299 Presumpscot St - Permit 2018-00338 (amendment)

I just completed my initial zoning review and I have some questions before I can approve the amendment for zoning and move it forward in the review process.

1 FIRST FLOOR PLAN
1/8" = 1'-0"

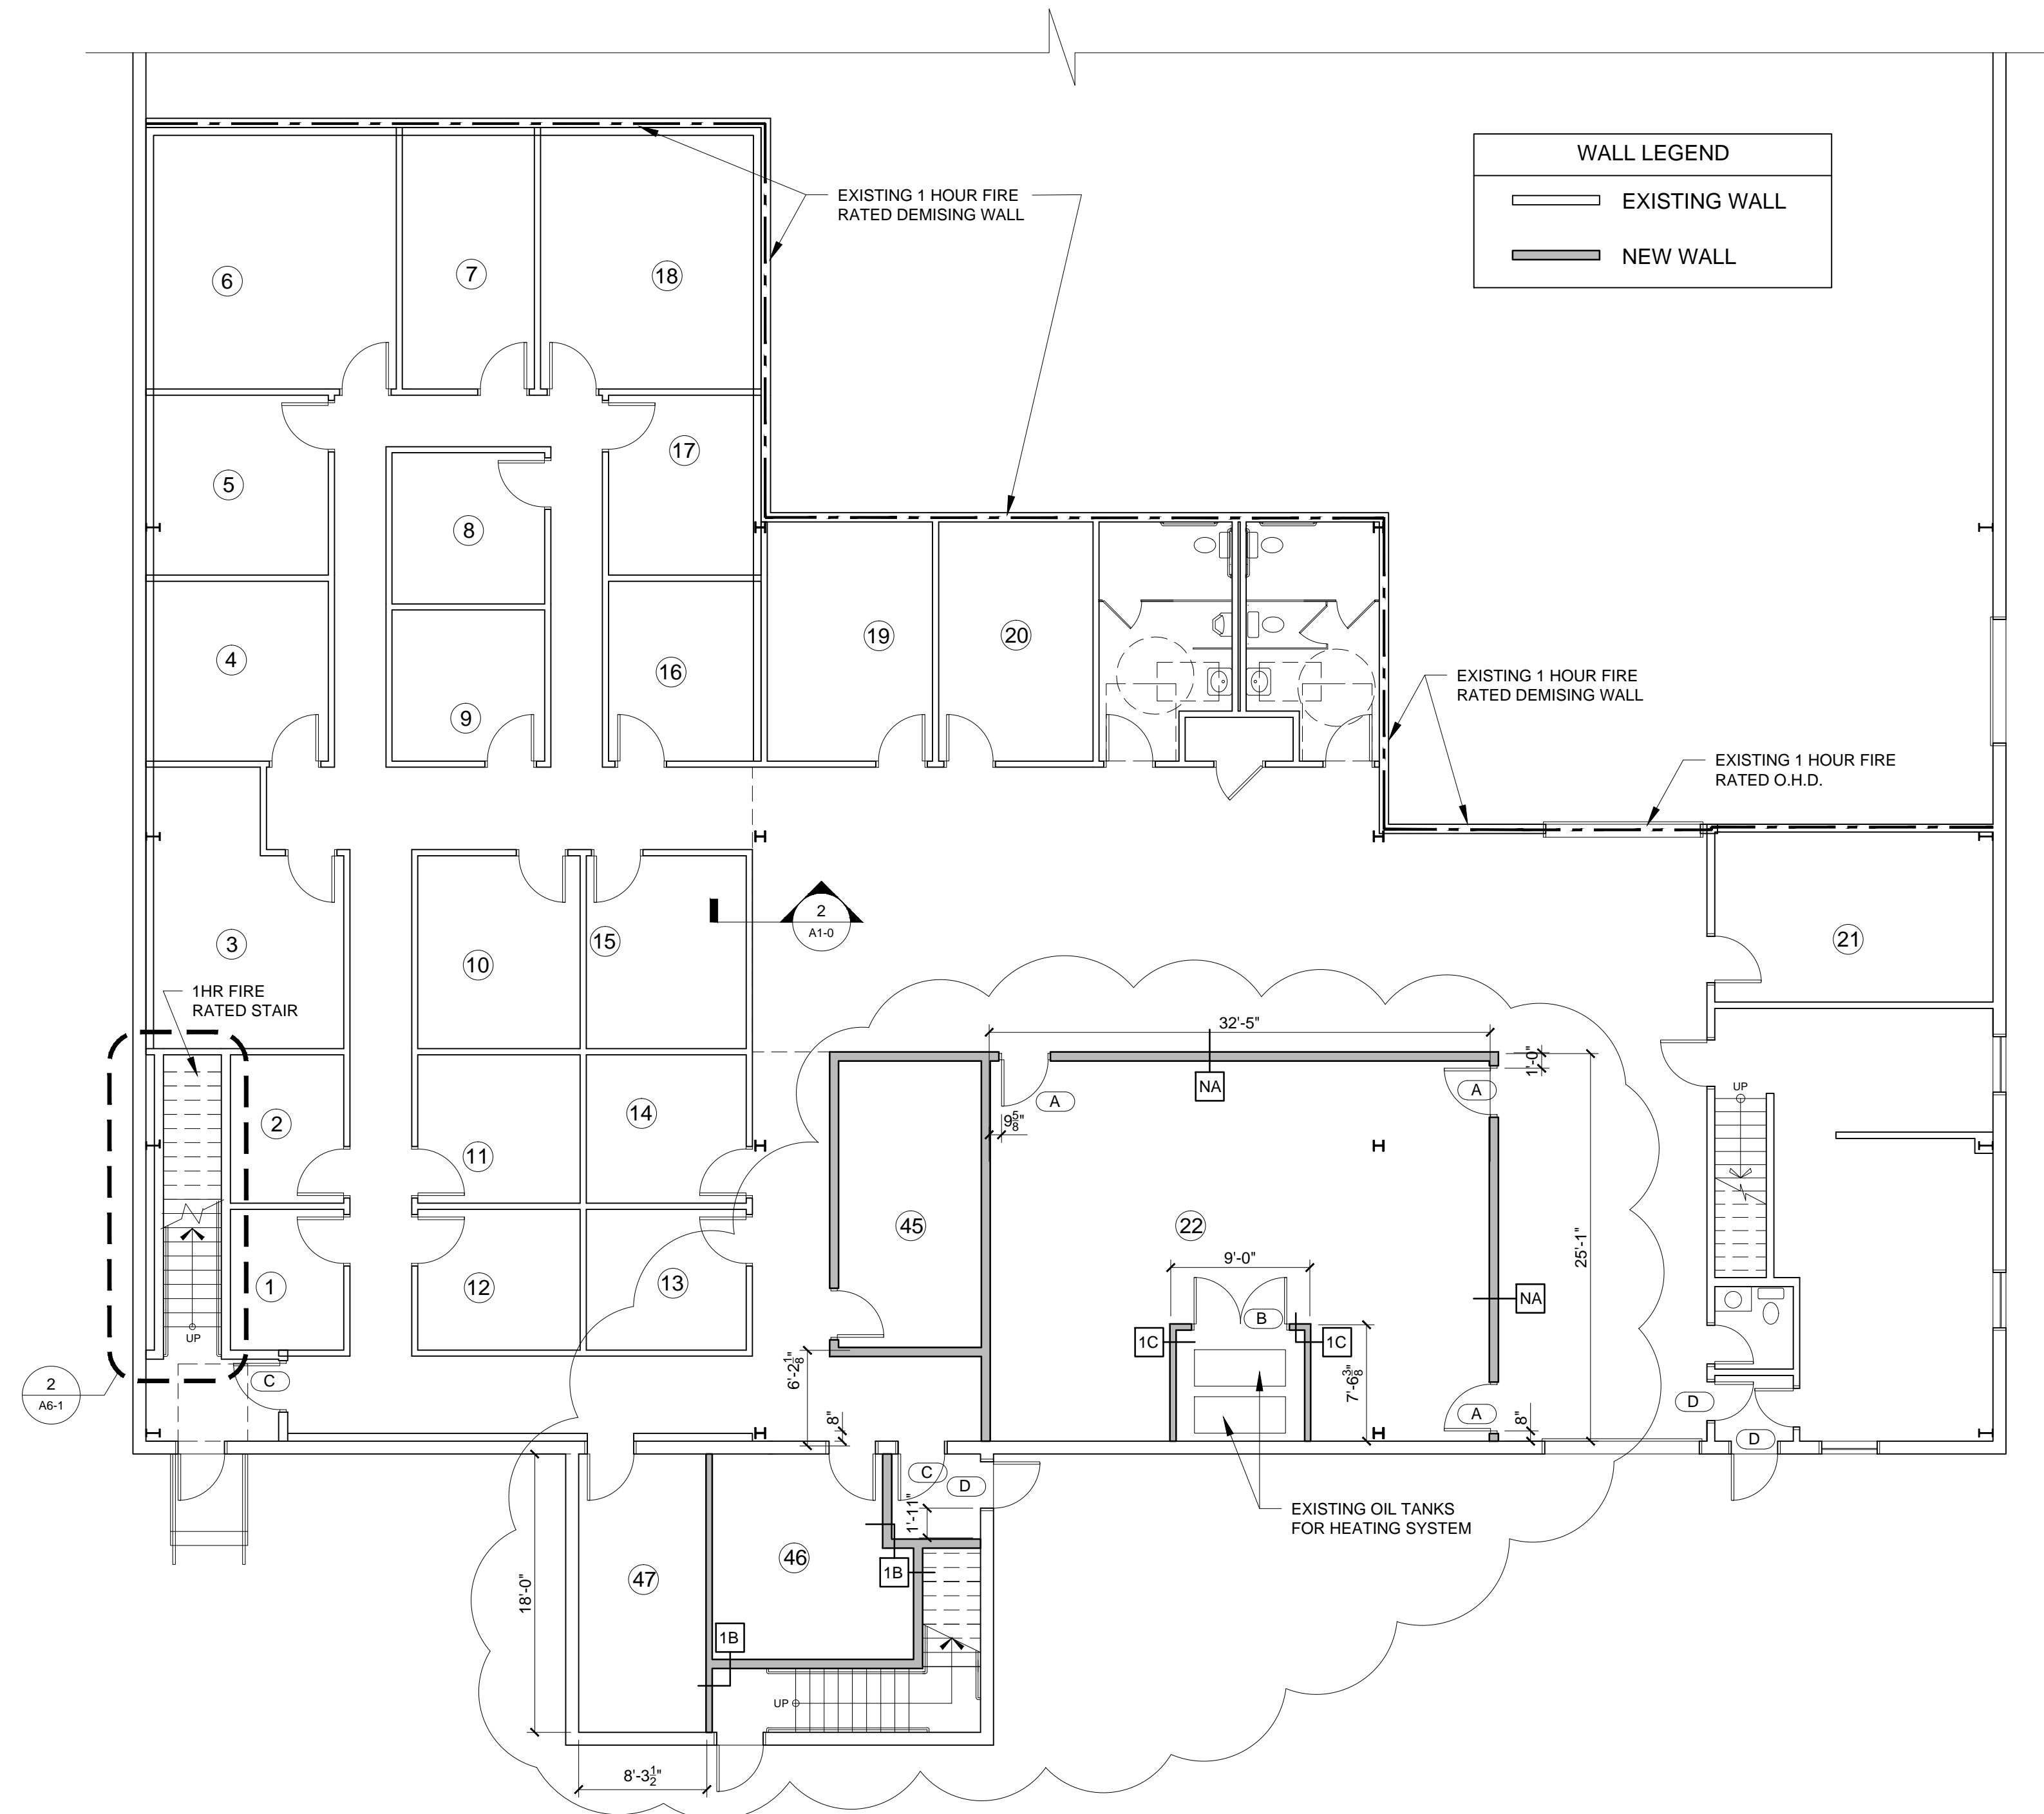
1. I have read the Amended Project Narrative for Phase 2 Part A. The space was originally approved as a rehearsal space for musicians (permit 2014-02379 & certificate of occupancy). Permit 2017-01887 called for the creation of an 18' x 30' single studio on the ground floor. Since this was not a change of use, the assumption was that this was another music rehearsal studio. It is not clear from the project description what the use of this studio is. Please submit a project description that explains exactly what this space is being used for. From the plan it looks like it is going to be a woodworking space.

2. The project narrative states that the "studio" will be 18' x 30'. In the clouded area of Plan A1-1, the dimensions for the area are 32'5" x 25'1" and on the shop layout plan the dimensions are 24.5' x 39'. What are the dimensions and please revise the plans and narrative to all be in agreement.
